Planning Consultation Memo

Date	Planning Officer	Environmental Health Officer
14/08/18	Clare Howe	Karl Riahi
Planning Application Number	Worksheet Number	
6/2018/1519/MAJ	WK/99178

Address: Land north of Chequersfield Welwyn Garden City

Application Details: Erection of 30 residential units with associated vehicular access, associated ancillary and enabling works.

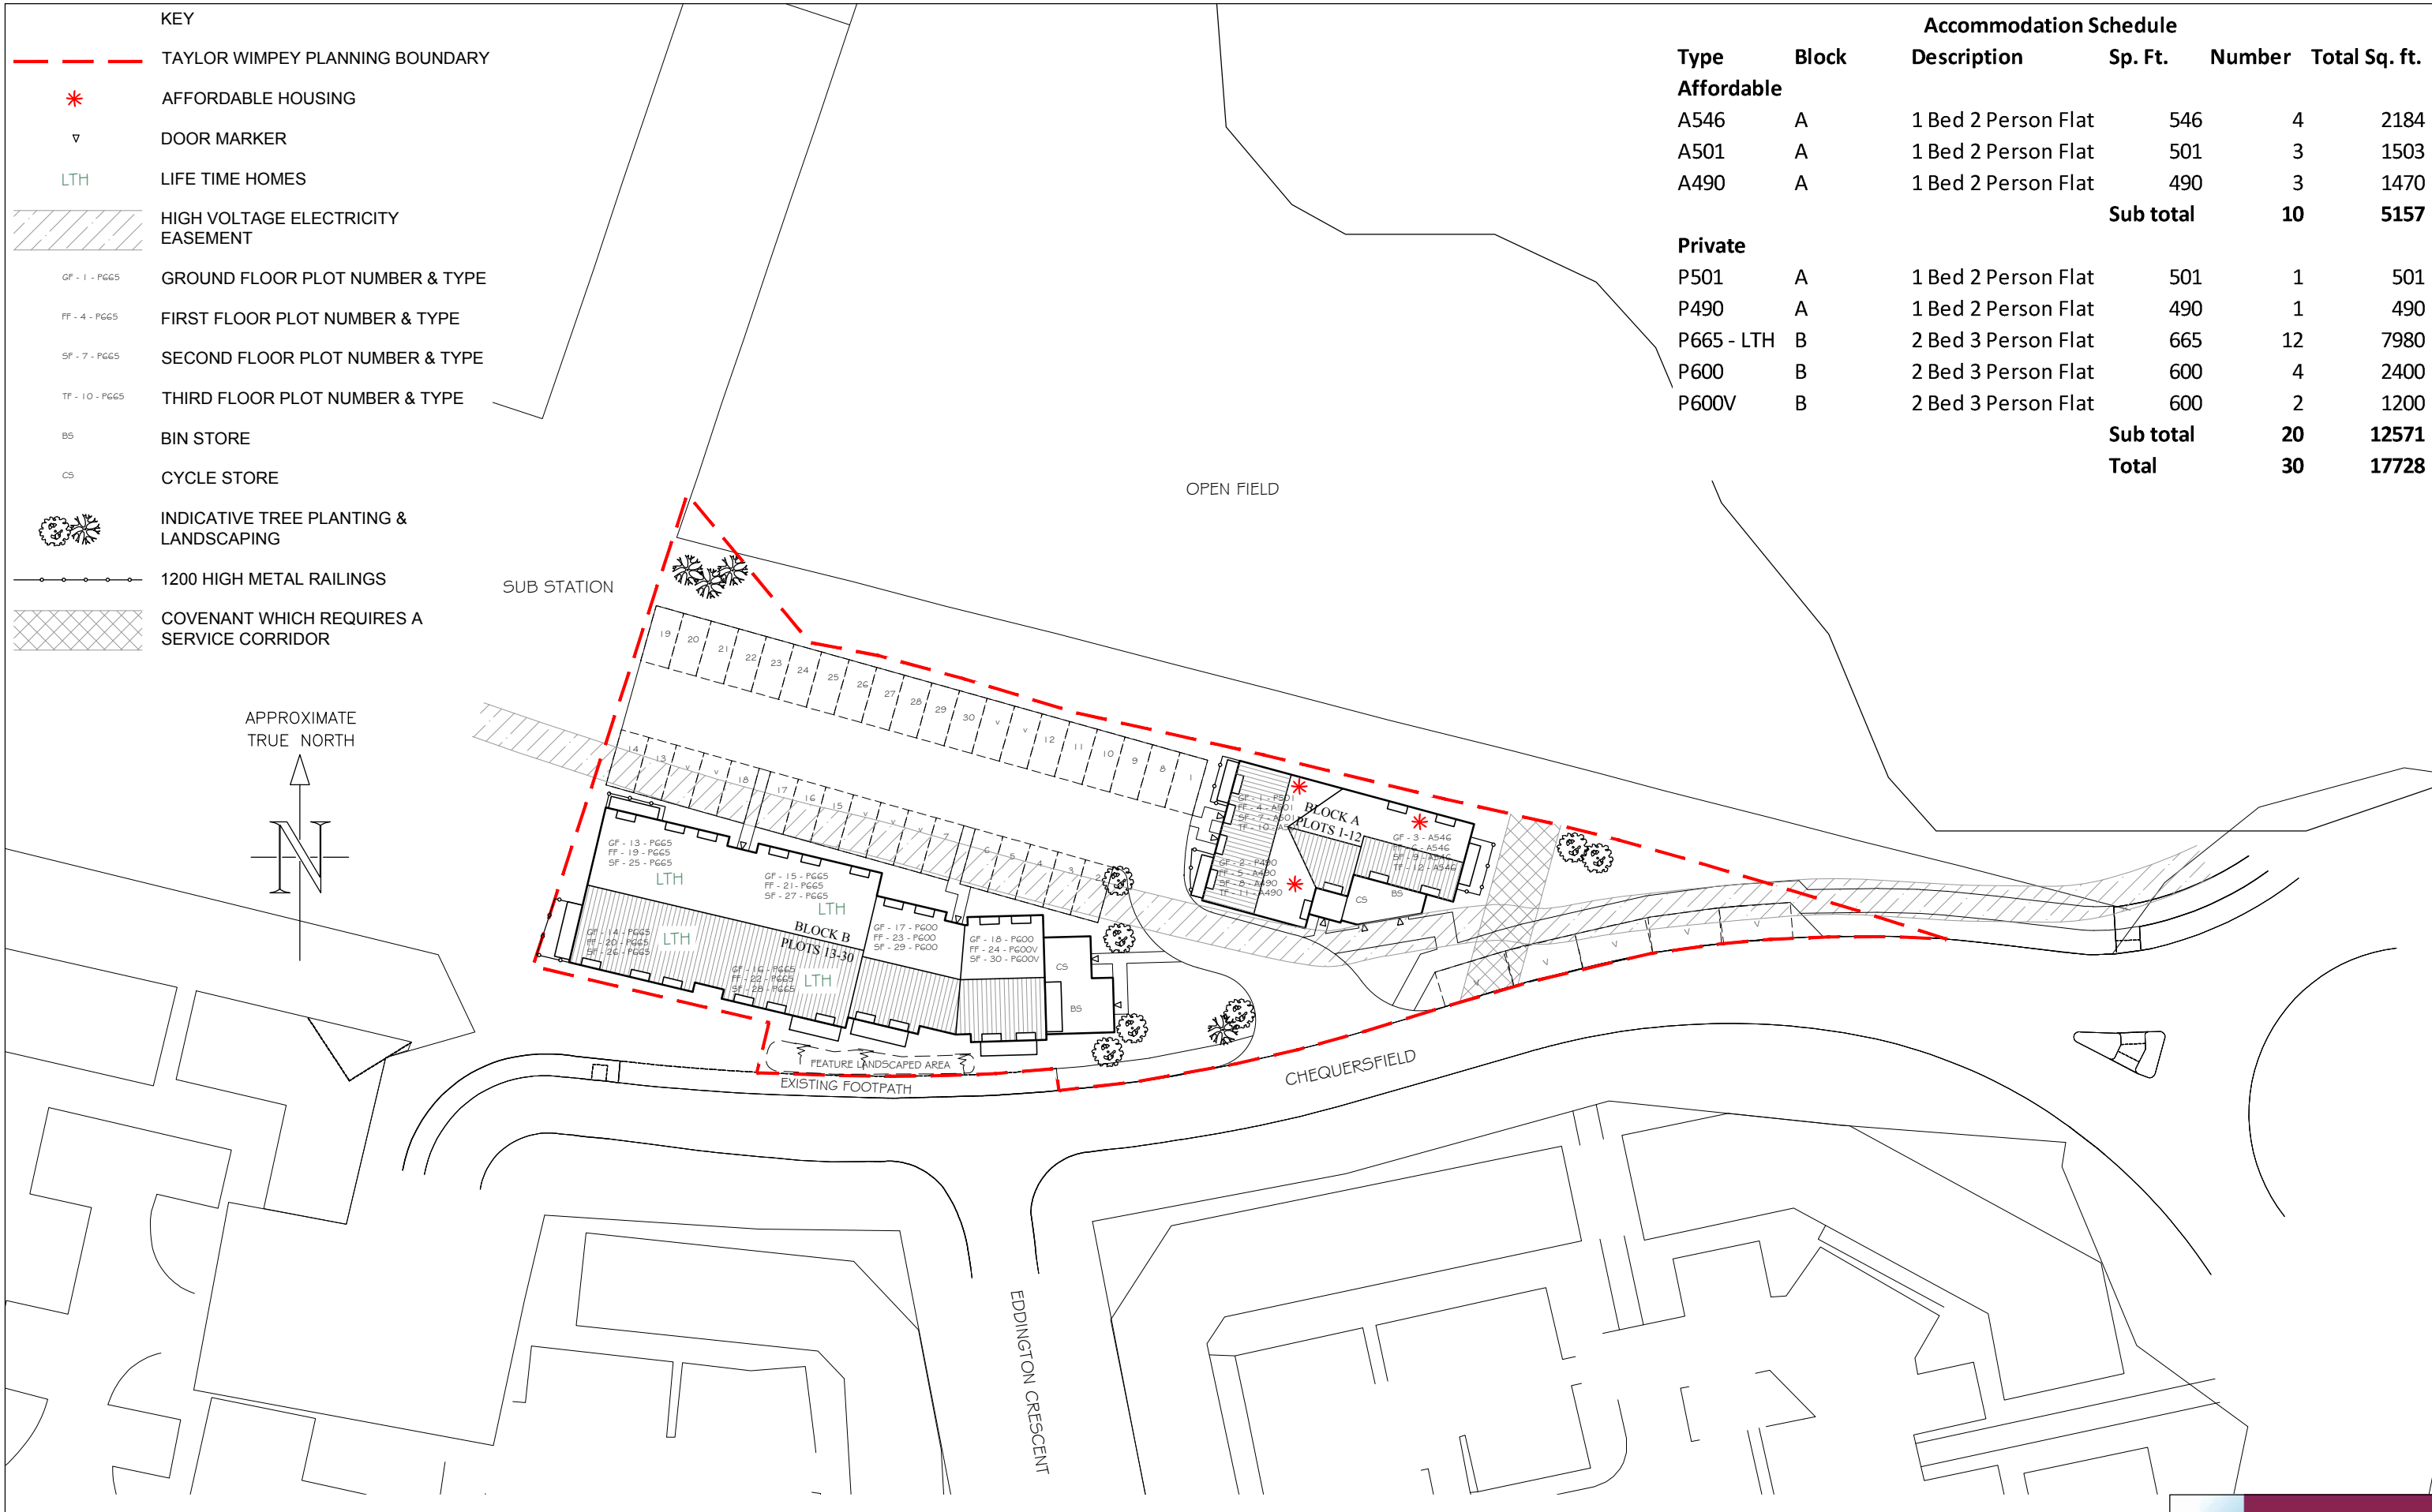
There is some confusion over the design of the development, the acoustic report states that there will be no balconies, however, other information now states that there will be balconies, and close to noise sources.

The outdoor amenity spaces, in this case balconies will need to meet the 55dB WHO Guidelines for Community Noise and we would expect information to be provided to support this.
